KITTTITAS COUNTY COMMUNITY DEVELOPMENT SERVICES

June 14, 2010

RE: Longbine Short Plat (SP-10-00002)

The Kittitas County Community Development Services Department has determined that the Longbine Short Plat (SP-10-00002) is a complete application and hereby grants *conditional preliminary approval* subject to the following conditions:

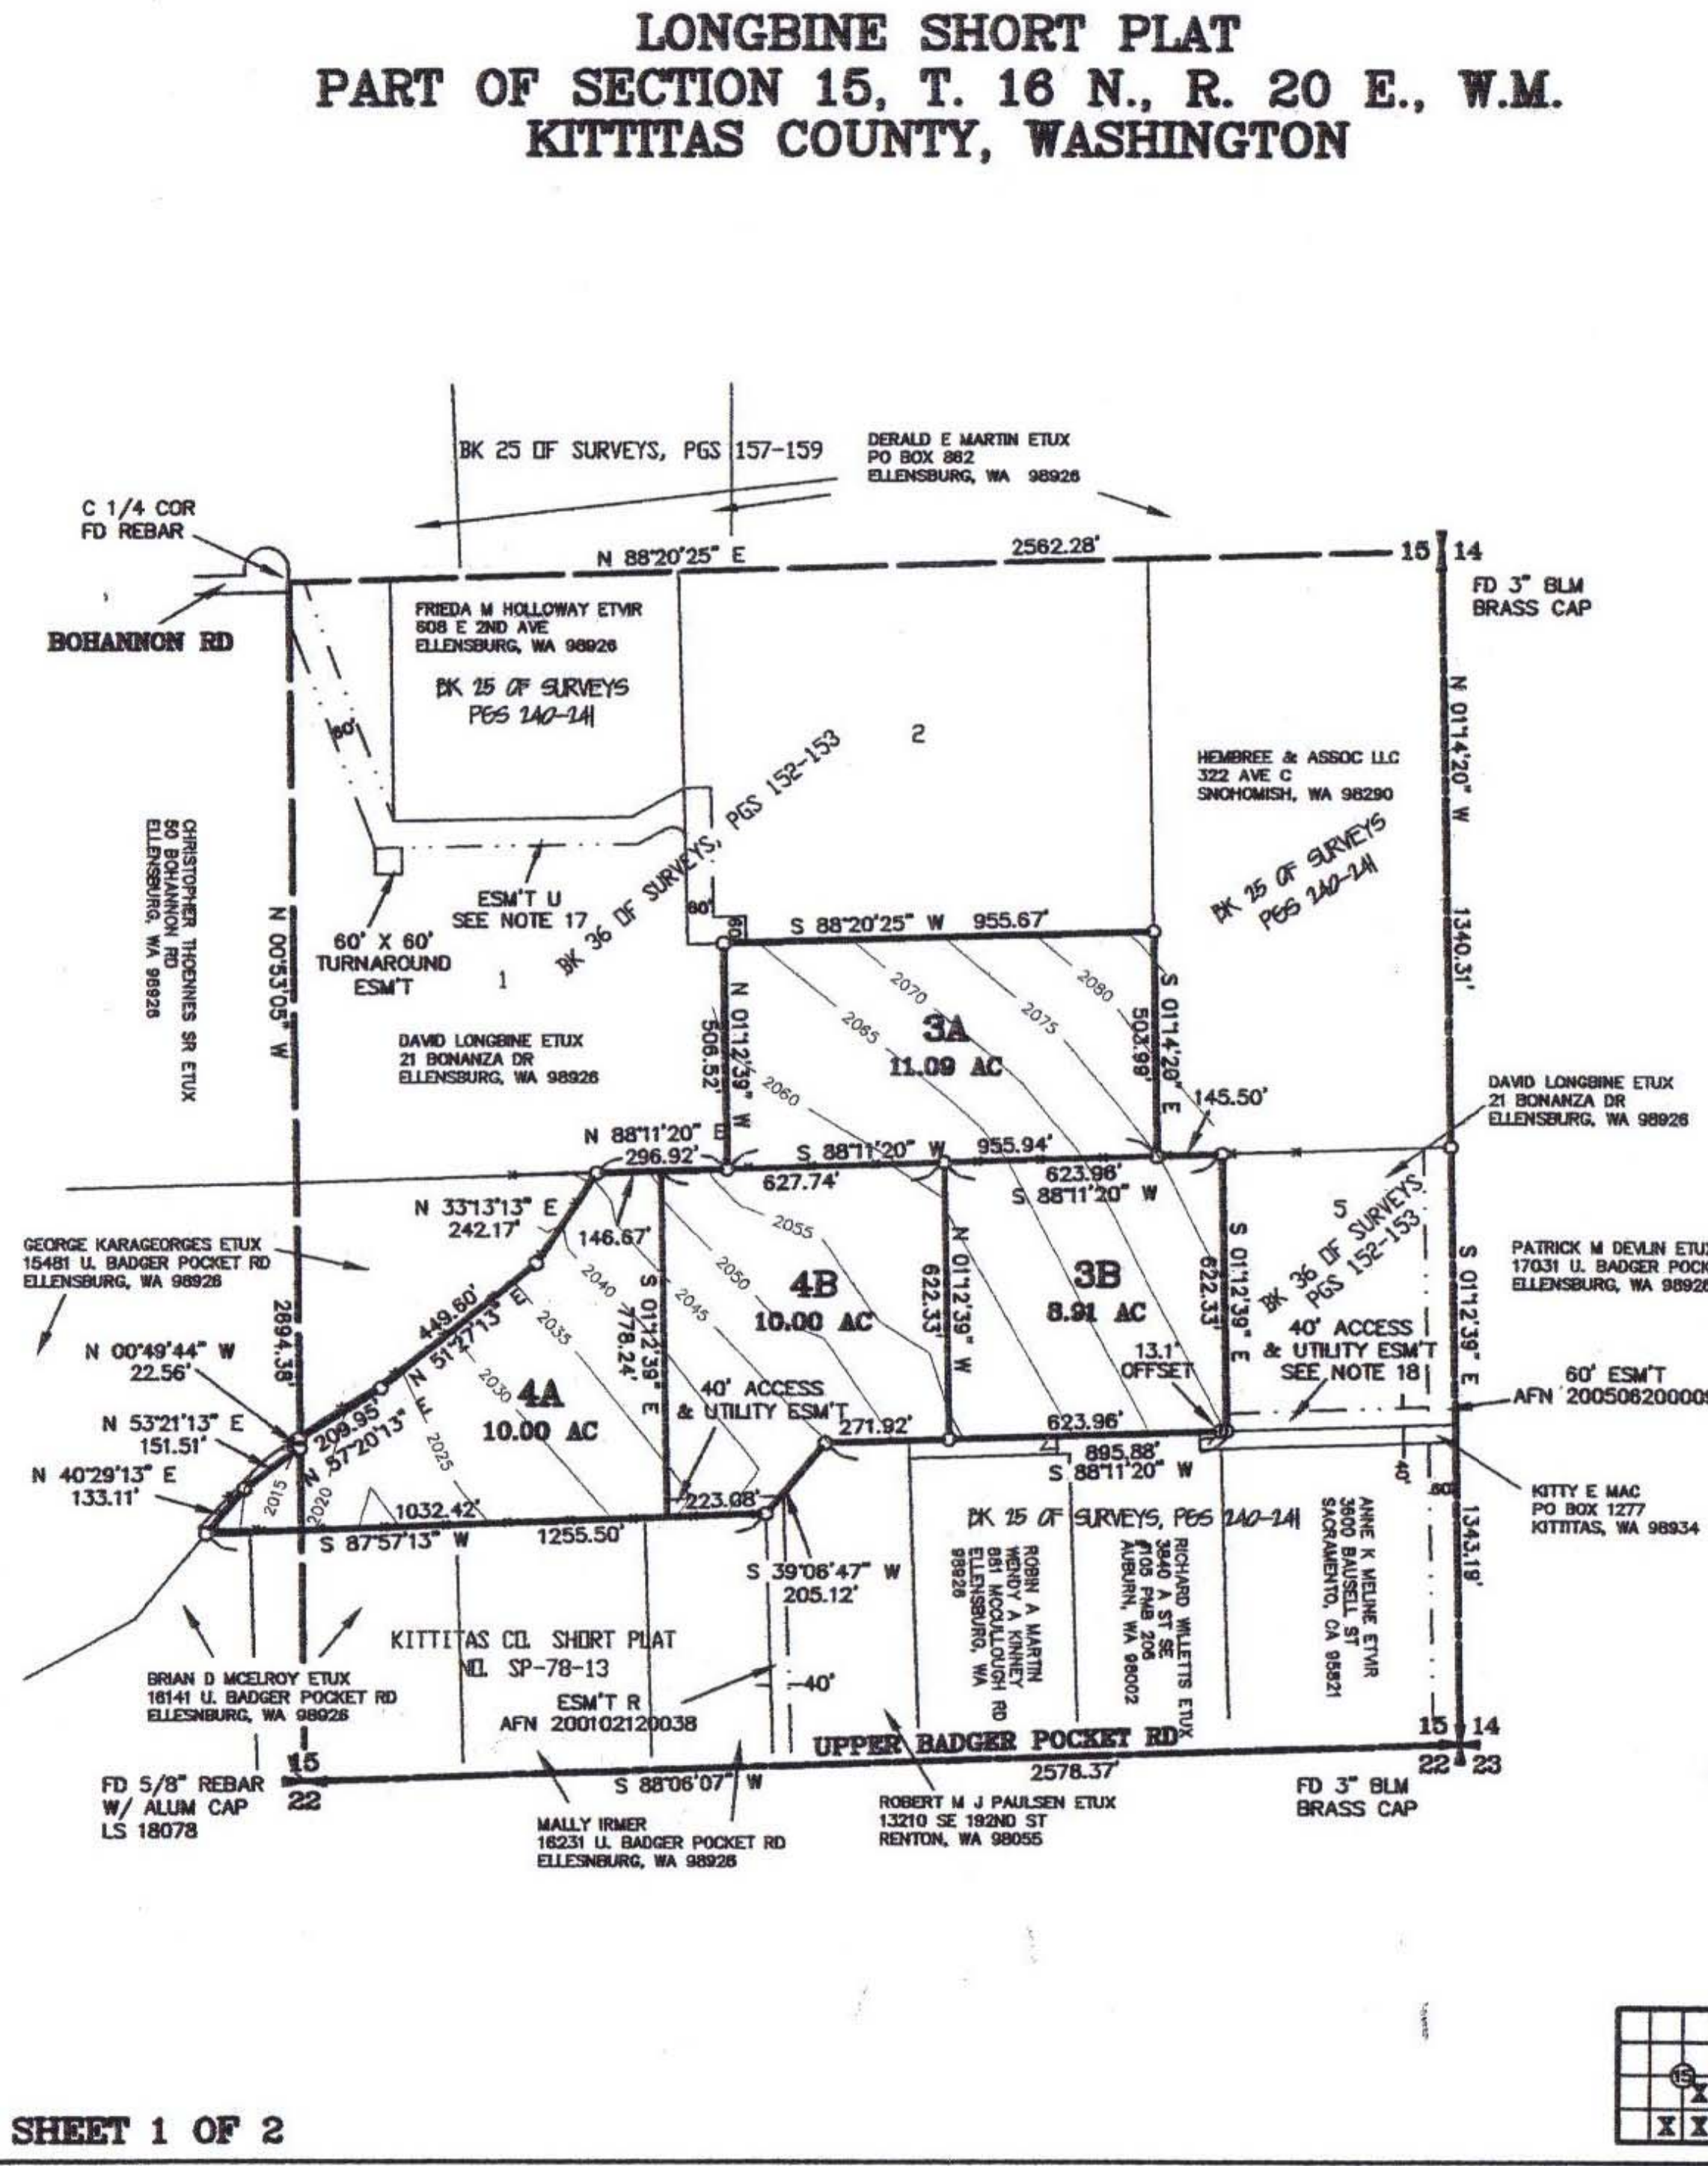
9. Lot 4B of the Longbine Short Plat has a PUB/EM1FH wetland in the center of the property. The Final mylars shall reflect the location of this wetland and a statement on the plat shall read as follows: "Future development of lots may require a study by a certified wetland biologist to determine wetland classification and for buffer requirements pursuant to KCC Critical Areas Code."

12. The addresses shall be clearly visible from both directions at the County Road for all properties.
13. The Fire Department access road shall be capable of supporting 75,000 lbs in all weather, be 20' wide, provide 13'6" vertical clearance and provide for adequate turn-around for fire department apparatus.
